From: Ian Hayward
Sent: 06 November 2014 13:40
To: Planning.Responses
Cc: Derek Whittington
Subject: RE: Planning Consultation on: AL/73/14/PL

SUBJECT: AL/73/14/PL - Erection of 2 no three bedroom semi detached dwellings (plots 1a and 1b) together with new boundary treatment & landscaping and extension of access road to serve site (part alternative to AL/114/12). This application affects a public right of way.

Land adjoining Sunnyside, Westergate Street, Westergate, West Sussex, PO20 3QR

Figure 1: Proposed Site Layout, with new Plots 1a & 1b shown within red line.

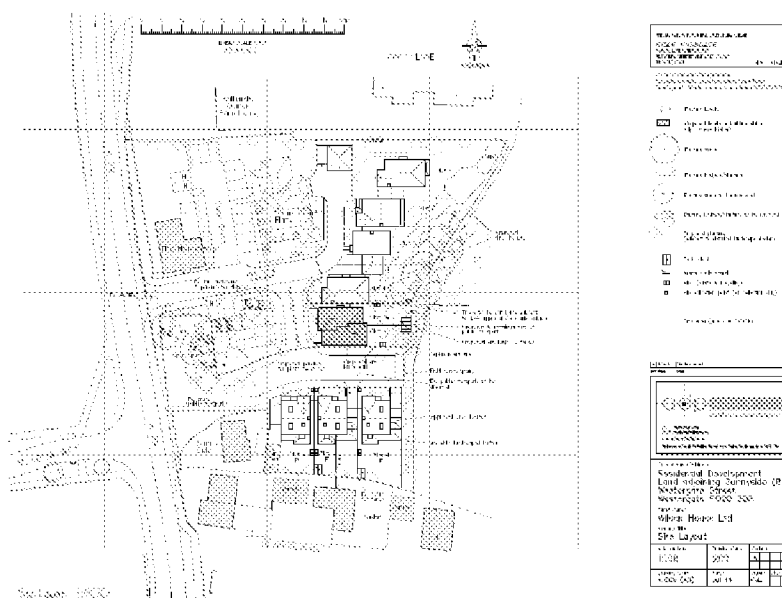
The dwellings would be provided with 2 x vehicle car parking spaces each. These would be provided in tandem on the opposite side of the private access road. It would be difficult to substantiate that the parking spaces in this location would be of detriment to highway safety given the low flow and low speed environment of the private access road. Two car parking spaces per dwelling in this instance would be considered acceptable. Secure and covered cycle parking large enough to store two cycles per dwelling should be provided, this does appear to have been demonstrated on the proposed site plan.

From inspection of the plans provided the physical build of this scheme, and the previously permitted scheme AL/114/12, is intended to cross the legal line of Public Footpath 297. I can confirm that F.P.297 also has additional rights as publically maintained highway as granted under the Highways Act 1980. Any planning consent must be conditioned to the effect that no development can affect the legal line of F.P.297 until and unless formal diversion has been achieved. Arun DC would be expected to act as Order-Making Authority. In addition the status of this public footpath as publically maintained highway will need to be "Stopped Up" under Section 247 of Town and Country Planning Act. The newly diverted line of public footpath F.P.297 will then need to be dedicated as public highway in the interests of continuity through a Section 38 Agreement.
